ENG-CDR20004-R5-CDs.pdf Markup Summary

Subject: Stormwater Comments Color
Page Index: 1
Date: 10/30/2022 7:46:18 PM
Author: dotprete
Color: ■
Layer:
Space:
Page Label: 1

SHEET 24 OF 99  
JOB NO. 25188.04

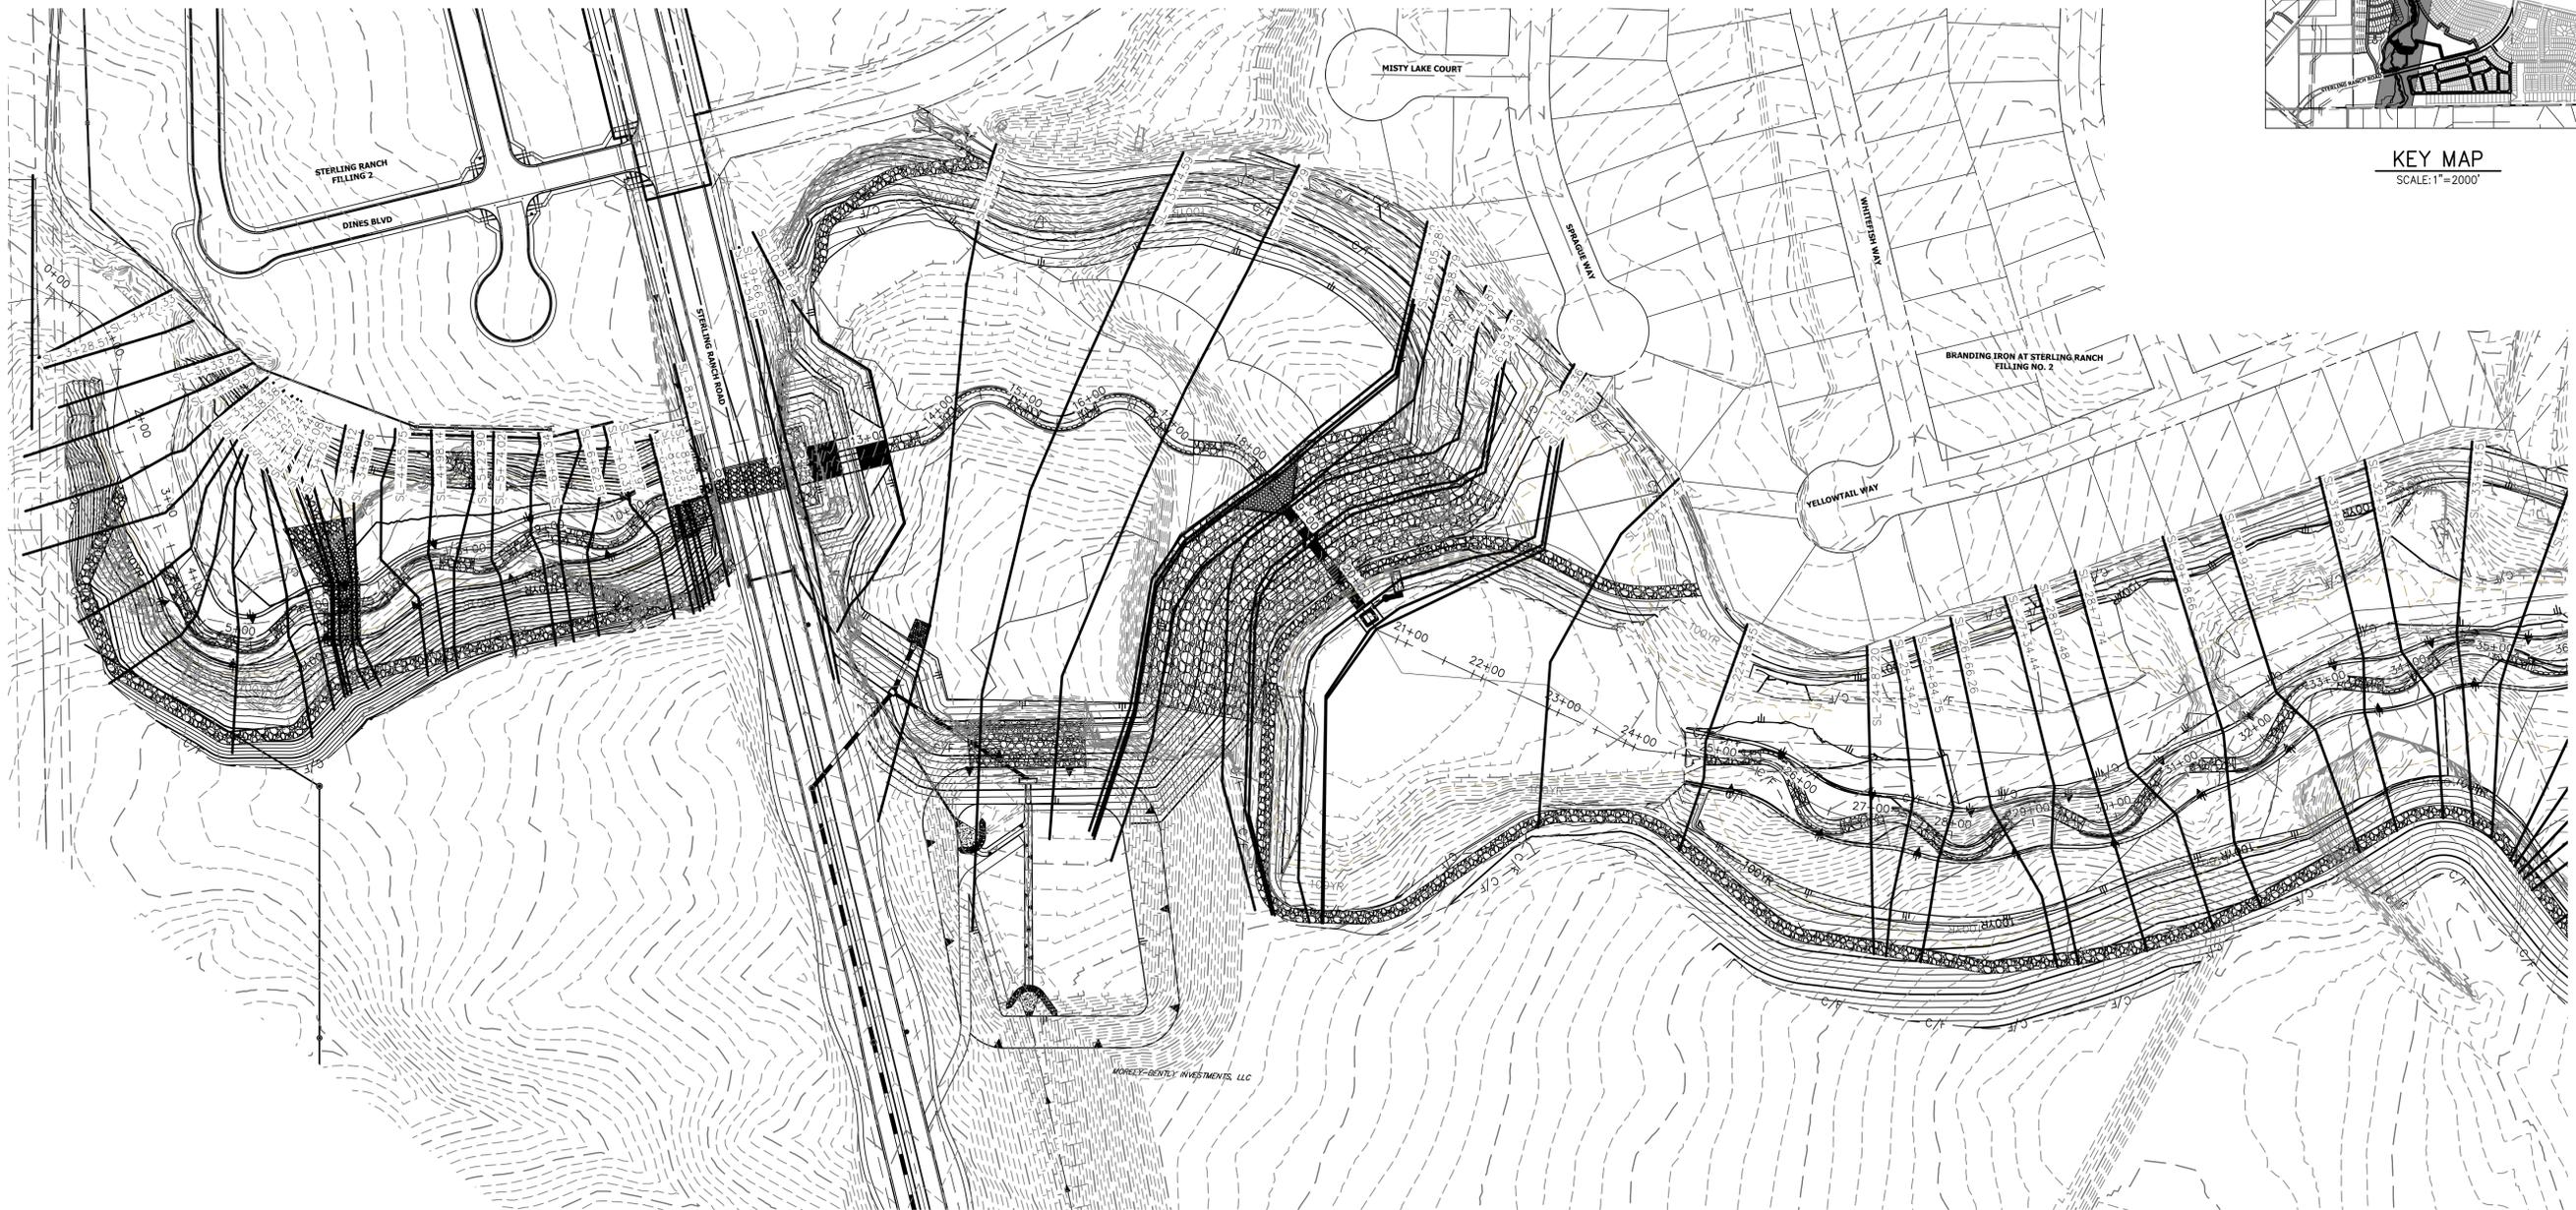
Label station, elevations

Label average channel grade

This line should be upstream from the top of each downstream grade control structure. Label stable grade. A dotted linetype might be better.

delete gray line?

SHEET 28 OF 81
 JOB NO. 25188.04

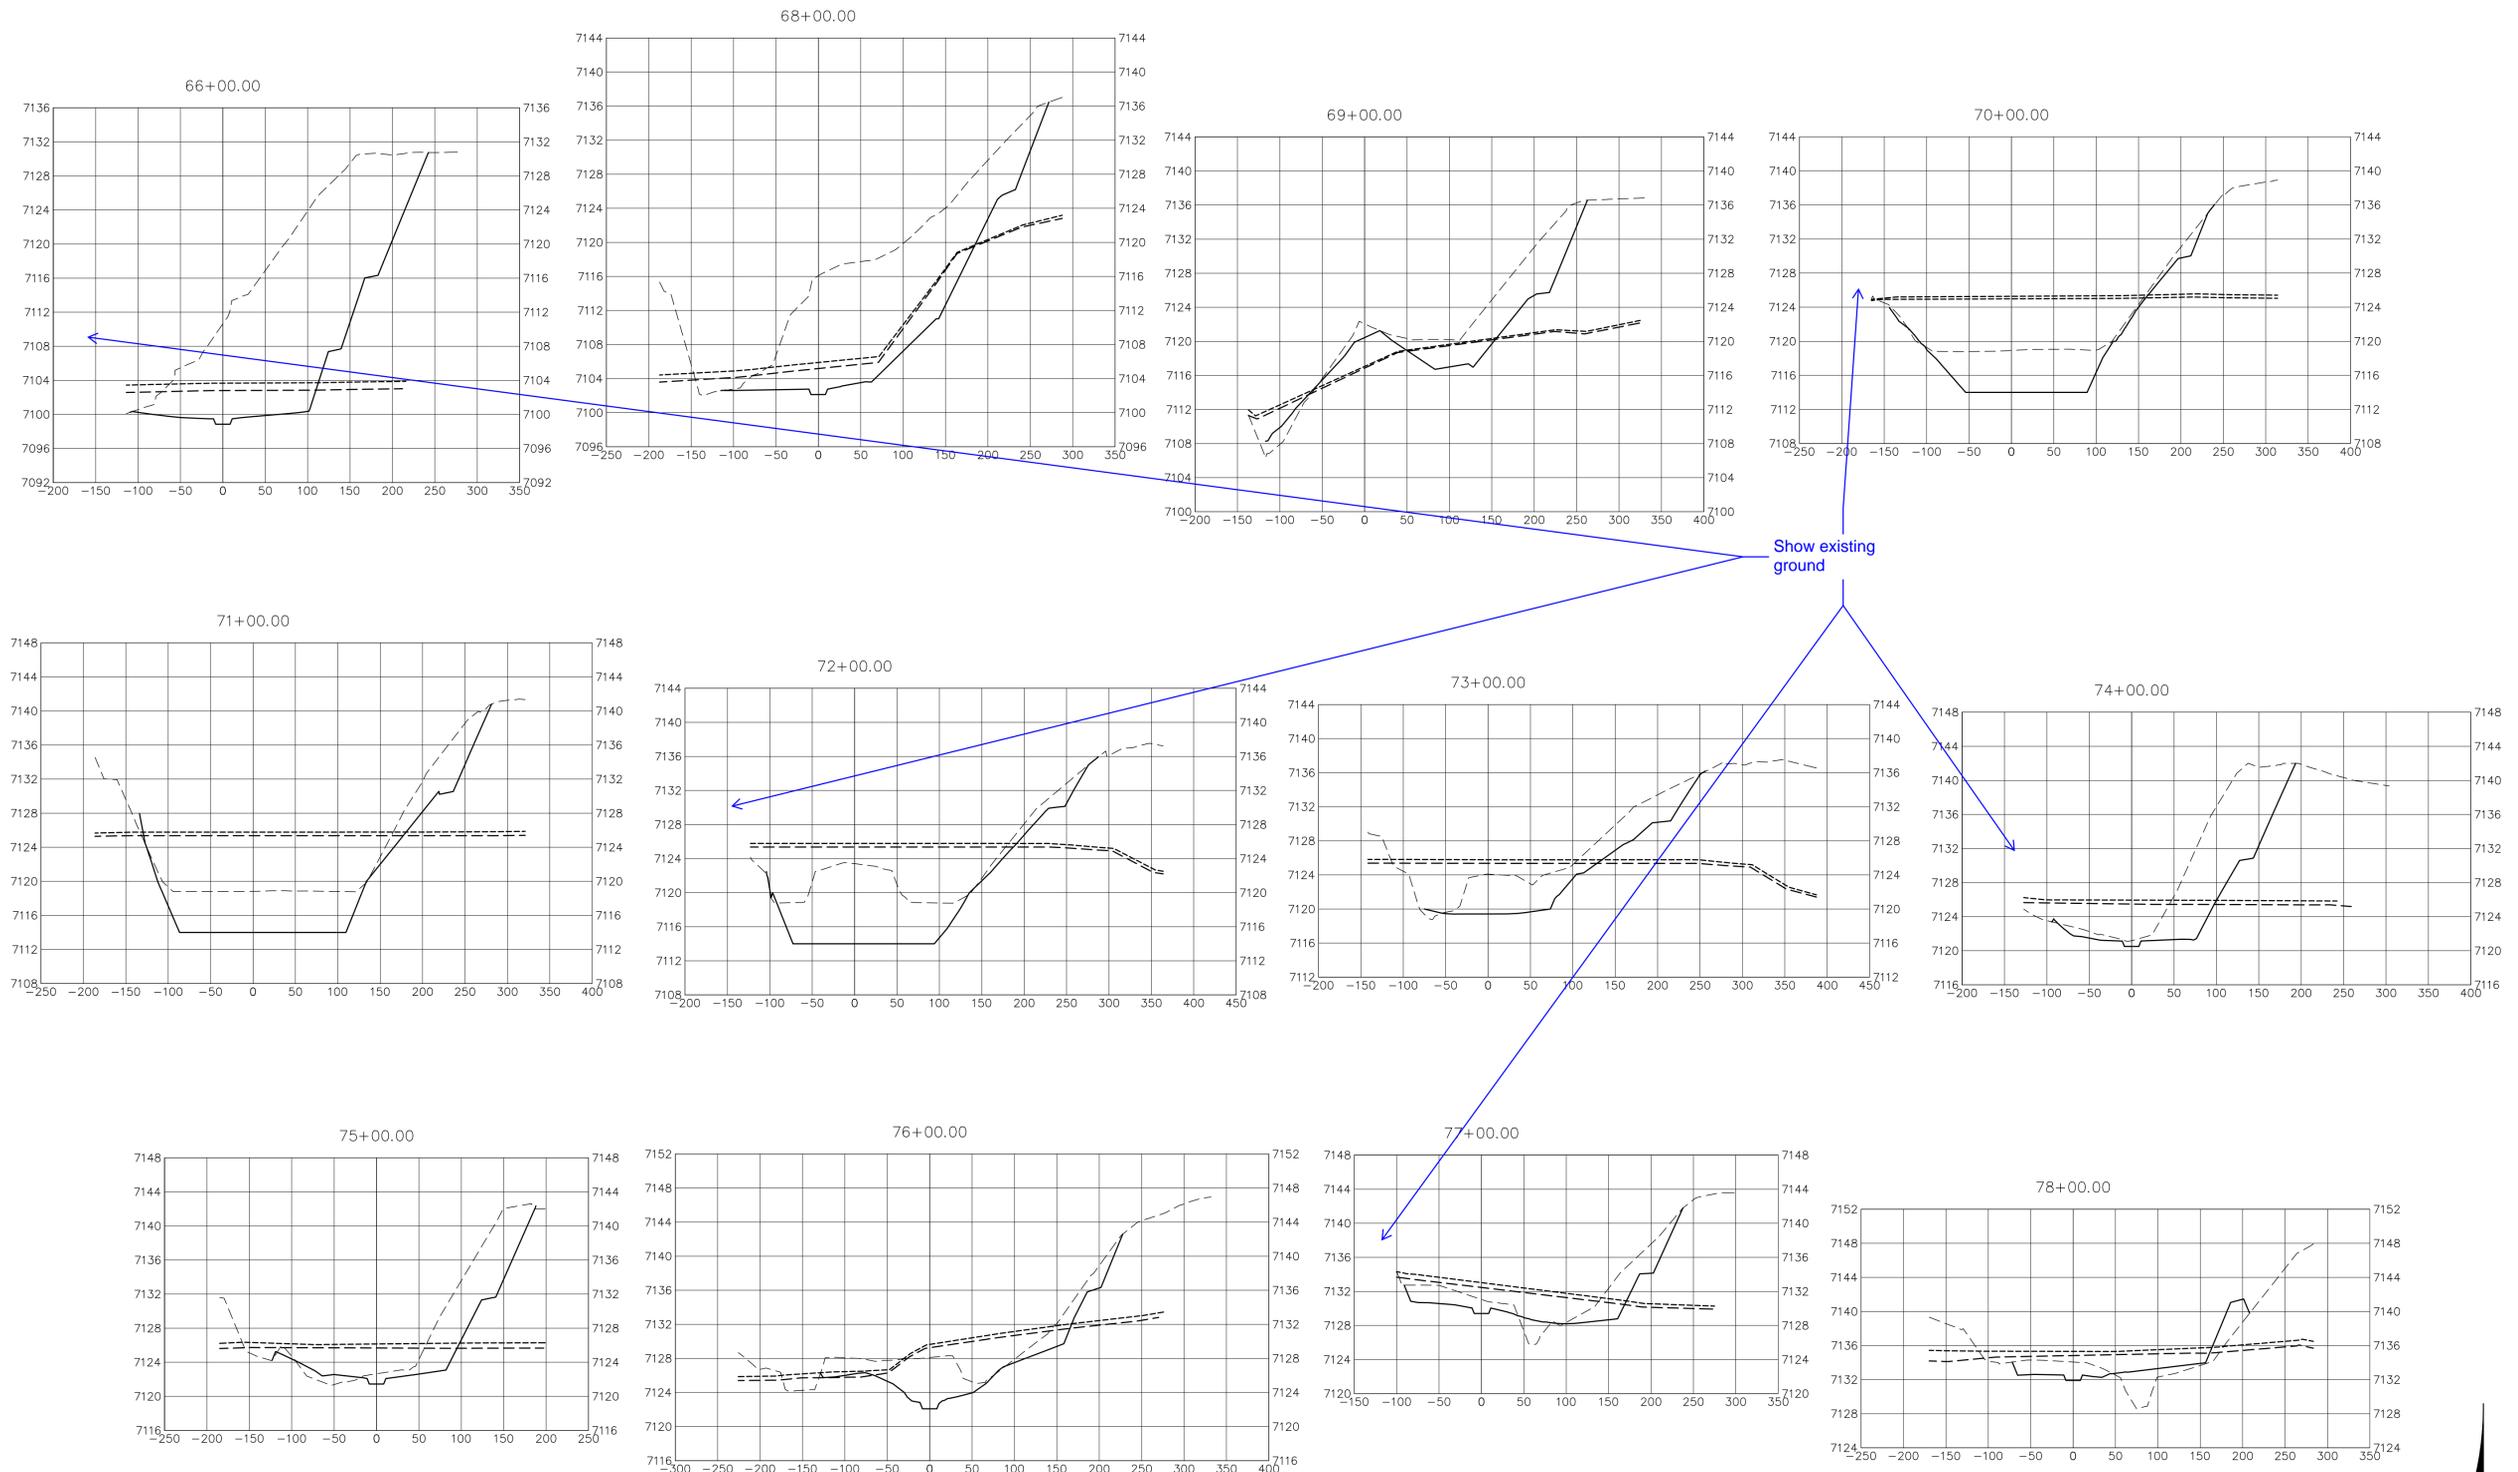
Complete all cross-sections

Show both maintenance roads/trail and lot lines
